# TECHNICAL NOTE 1

<b>DATE:</b>	14 March 2023	<b>CONFIDENTIALITY:</b>	Public
<b>SUBJECT:</b>	A66 - Principal issues to be addressed with the Environmental Statement		
<b>PROJECT:</b>	A66 NTP	<b>AUTHOR:</b>	Various
<b>CHECKED:</b>	Various	<b>APPROVED:</b>	Hywel Roberts

Suitability	Suitability Description	Revision
S4	FIT FOR STAGE APPROVAL	P02

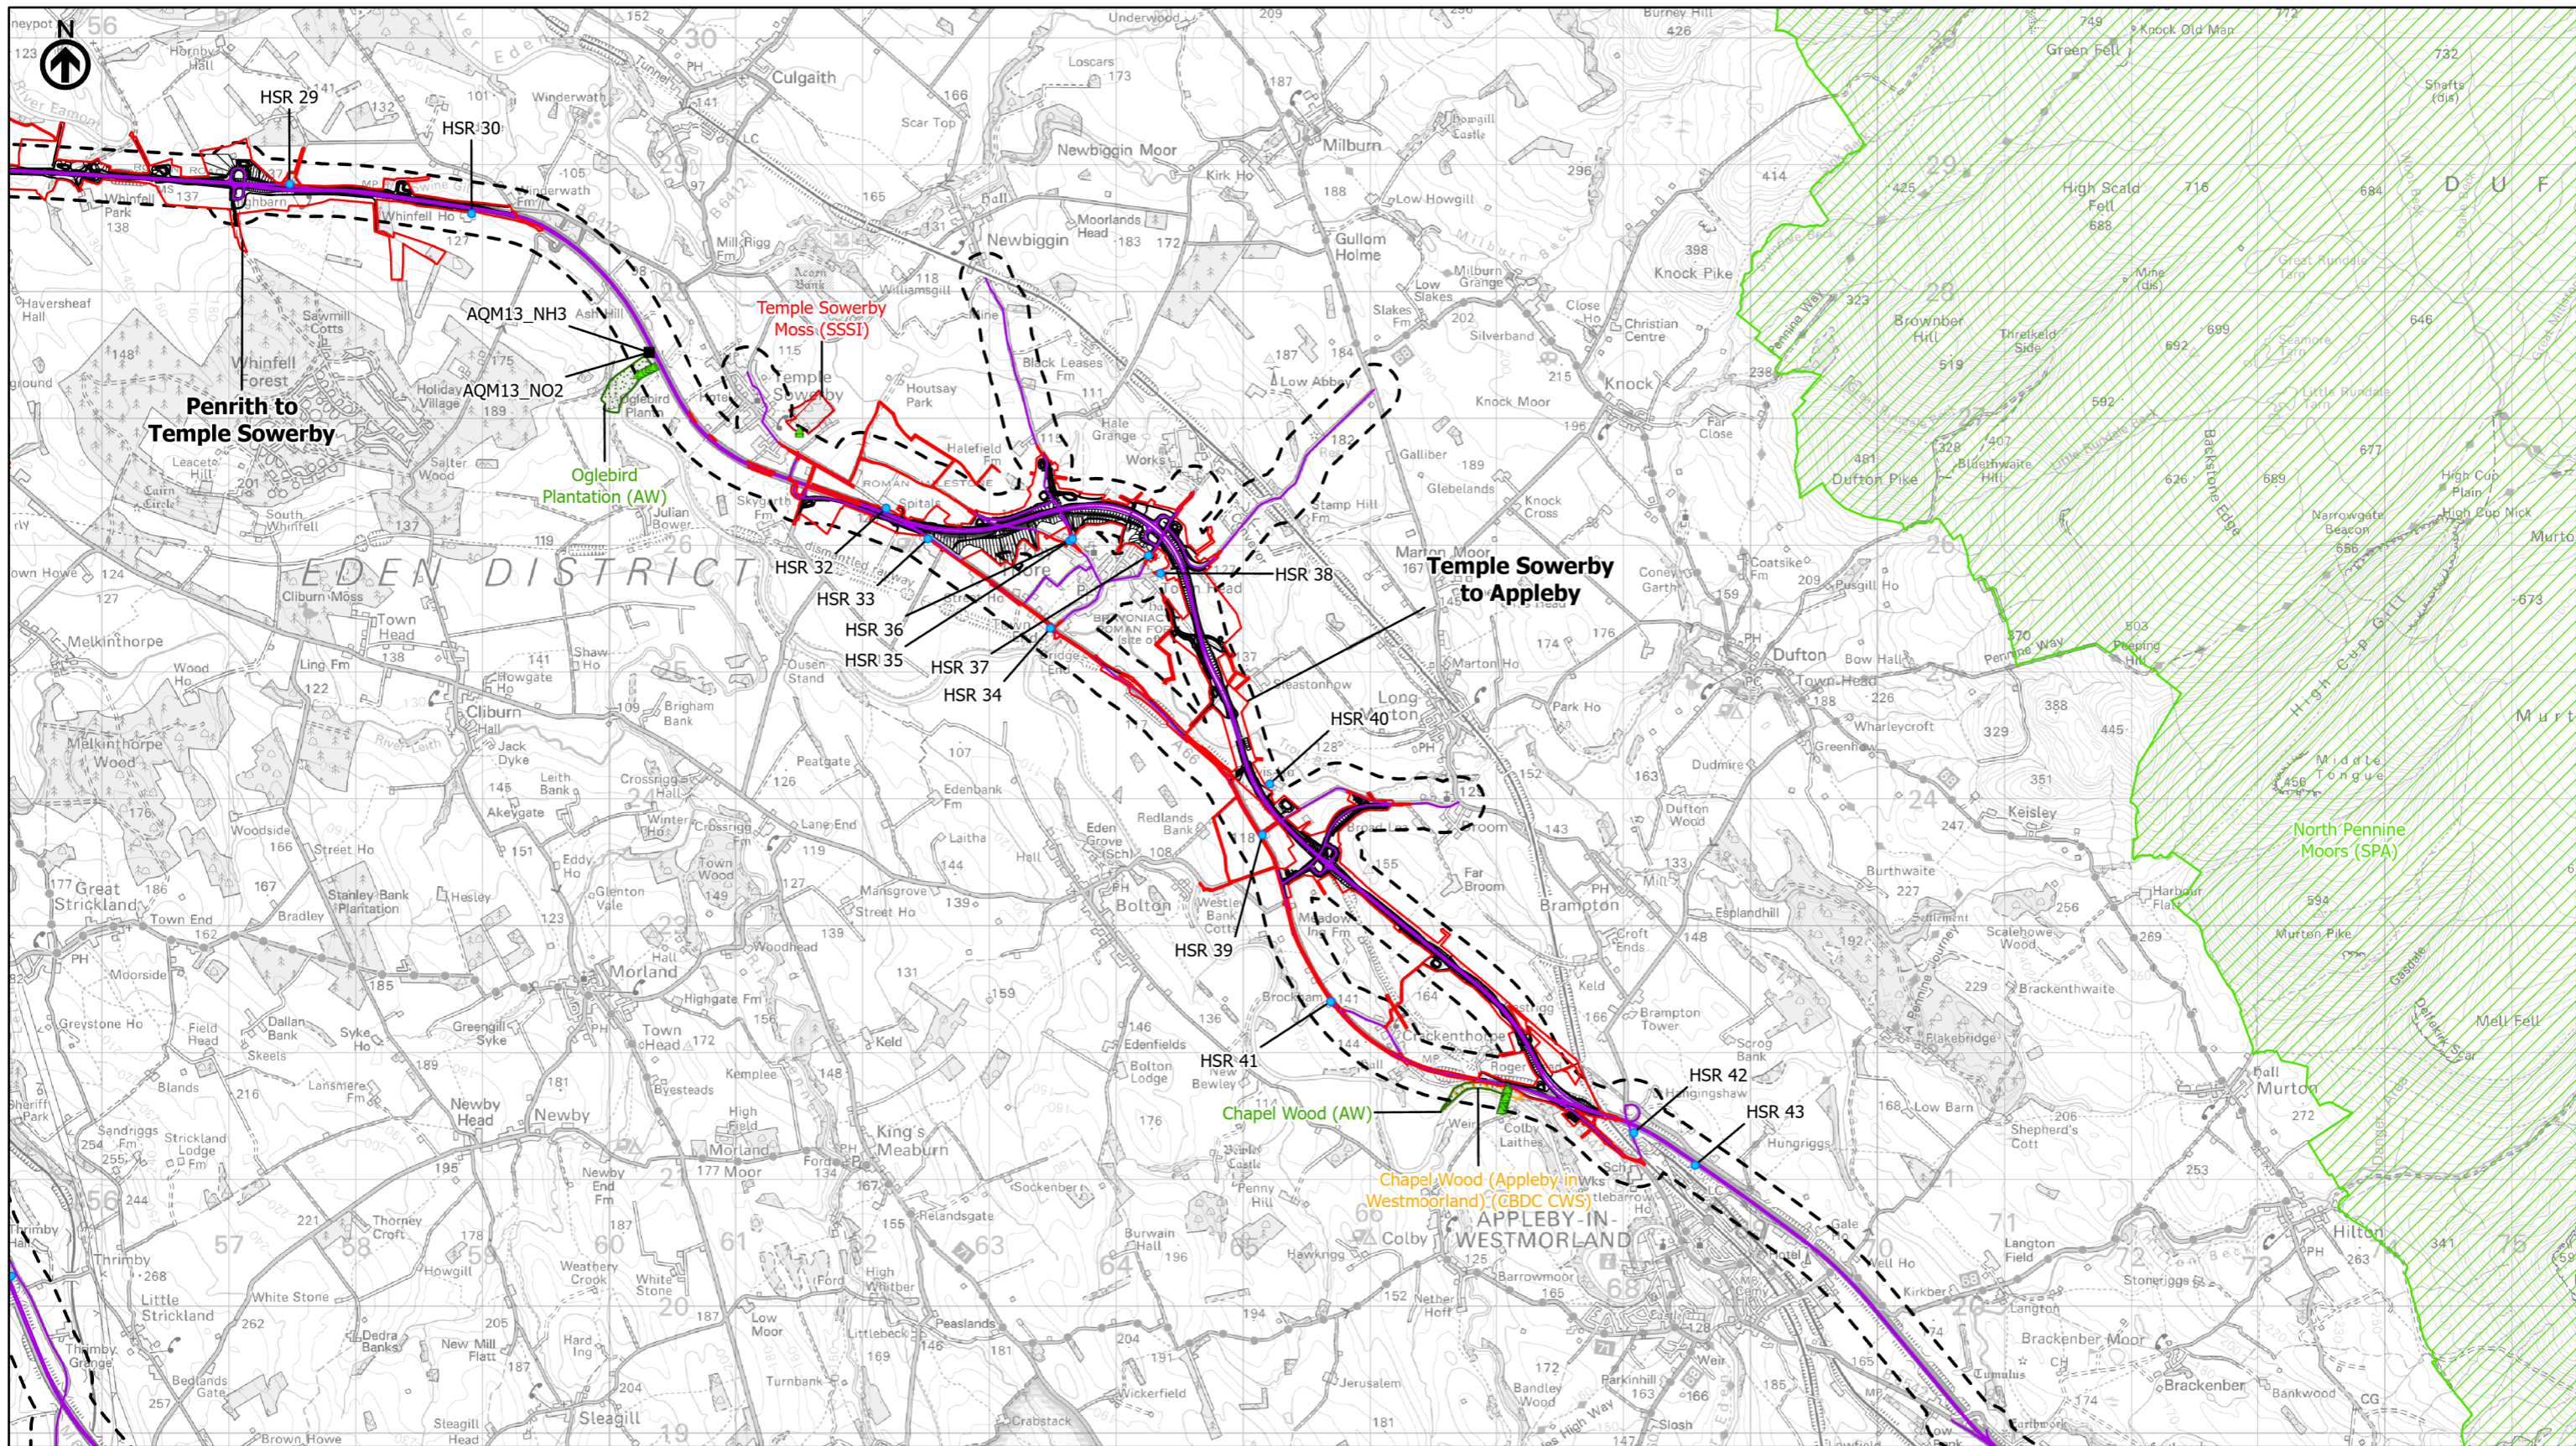
Without prejudice to comments raised by the Councils in response to National Highways response to Written Question AQ 1.1 and with reference to Environmental Statement Figure 5.1 sheet 3/15, Castlegate forms part of the Affected Road Network the Councils are unsure of the modelled impact. There appears to be a conflict with the data presented in Plate 1 of section 2.1.2 Appendix 2.1 Traffic Modelling Report in

which the traffic flows appear to reduce by less than 2,000 AADT. On this basis, it appears that air quality impacts have not been assessed on Castlegate despite elevated monitored concentrations on this road and the presence of long-term human exposure.
